Your Ref: 2024/91507

Application 2024/91507 – Erection of agricultural building at Thorncliffe Farm Shop, 1, Westfield Lane, Emley Moor, Huddersfield HD8 9SZ

PROPOSED EQUESTRIAN BUILDING AT THORN CLIFFE FARM ARENA,
WESTFIELD LANE, EMLEY MOOR, HD8 9SZ. ELEVATIONS 1:100 @ A4

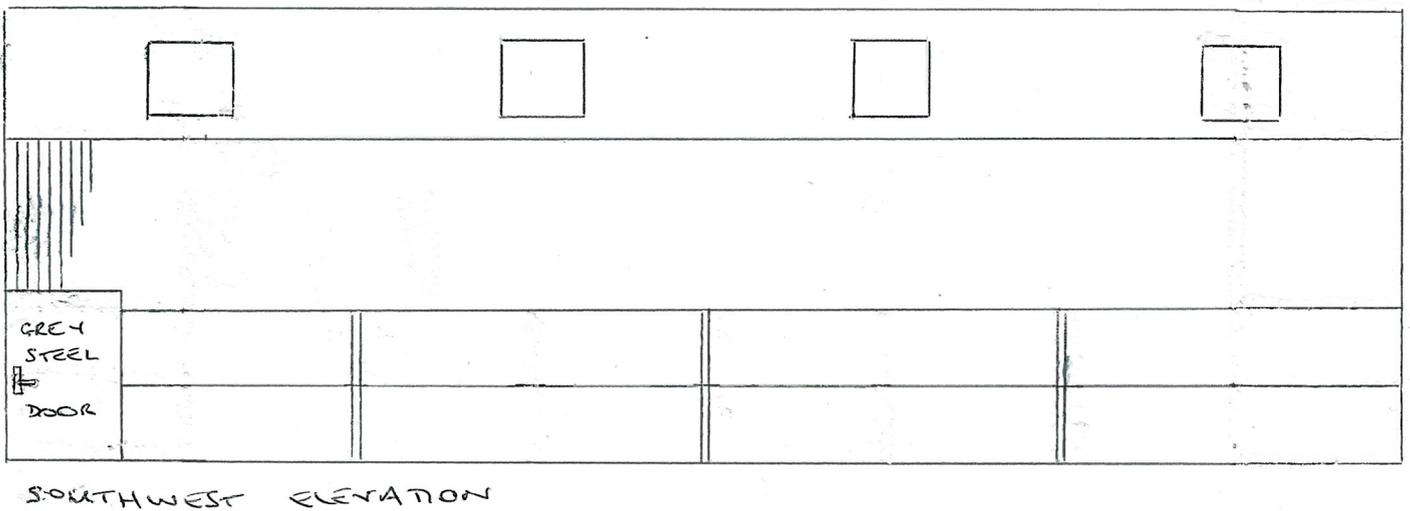
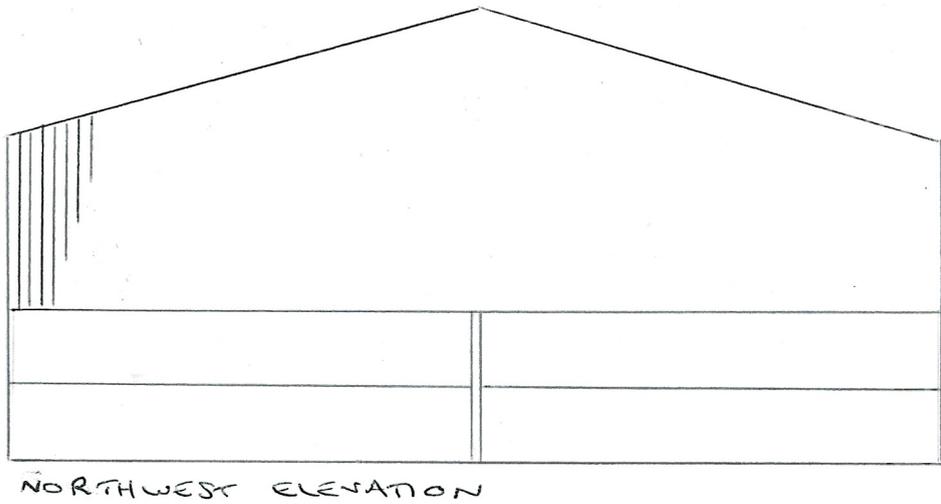
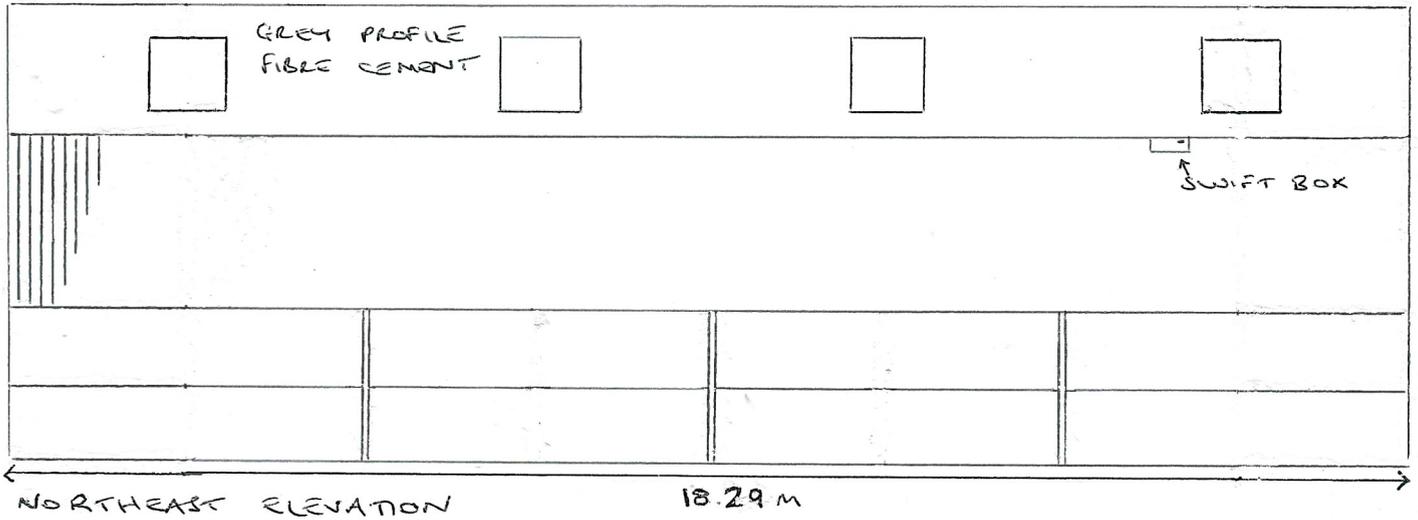
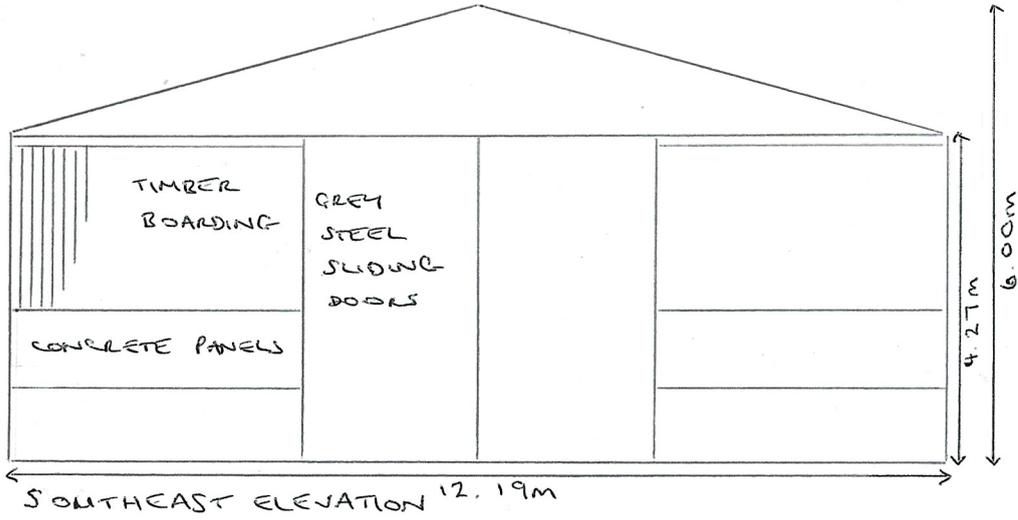
The proposed agricultural building would have a footprint of 18.29m x 12.19m & a height of 6m & along with the location, it is almost a repeat of the 2020 application that was withdrawn. It should also be noted that the elevation plan supplied refers to the building as an *"equestrian building"*, which suggests its real purpose & future use.

Proposed Agricultural Building at Thorncliffe Farm Shop,
Westfield Lane, Emley, HD8 9SZ
Block Plan 1:500 @ A4 April 2024

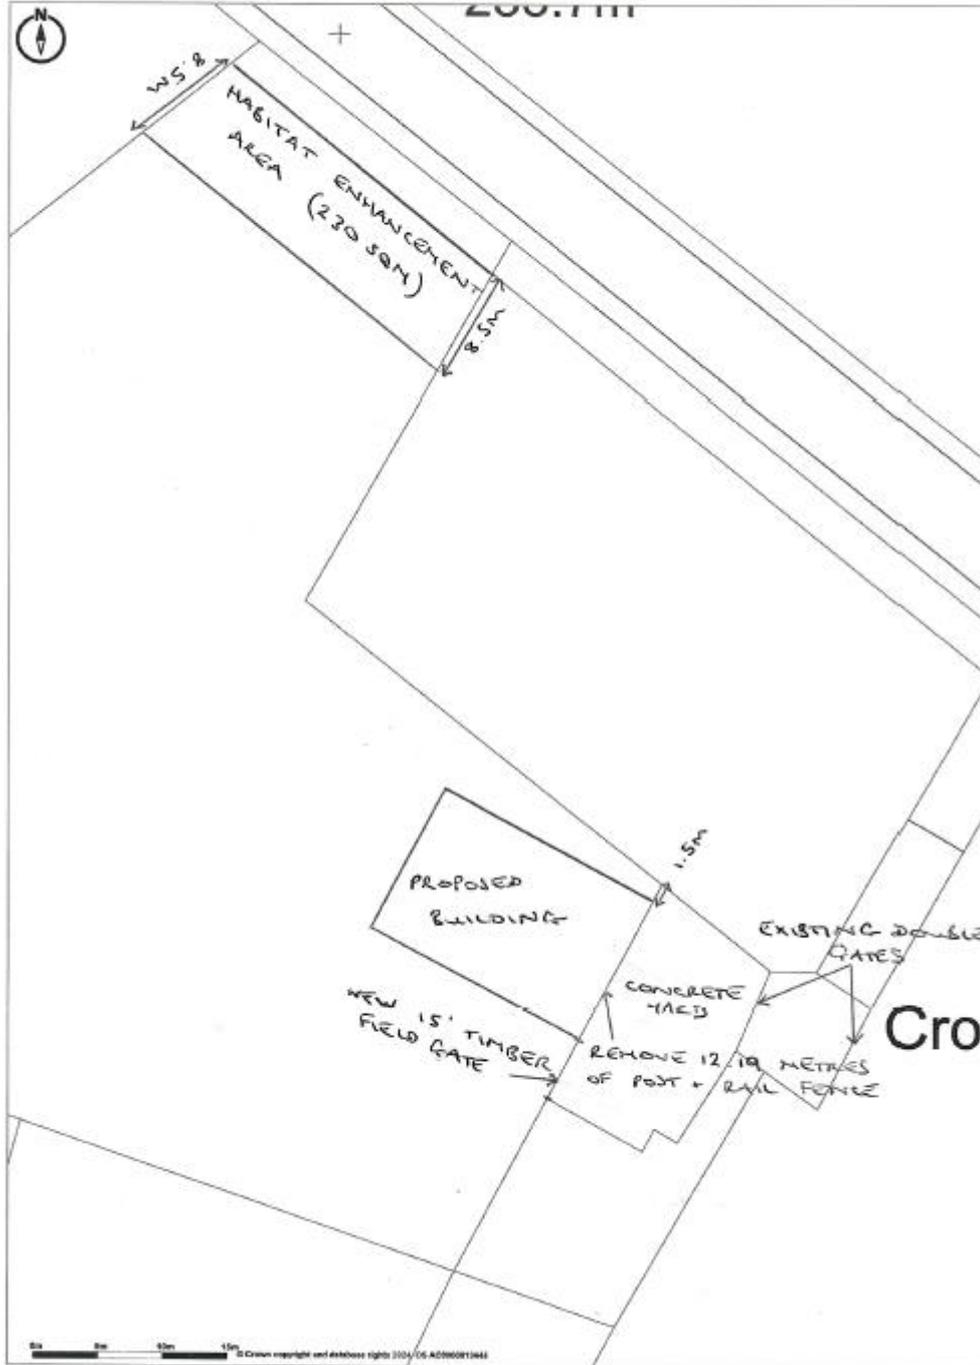
- The location, block & habitat plans supplied are **invalid** as they refer to the site as Crowtree Farm which is sited further on Westfield Lane to the Northwest (post code HD8 9TD).
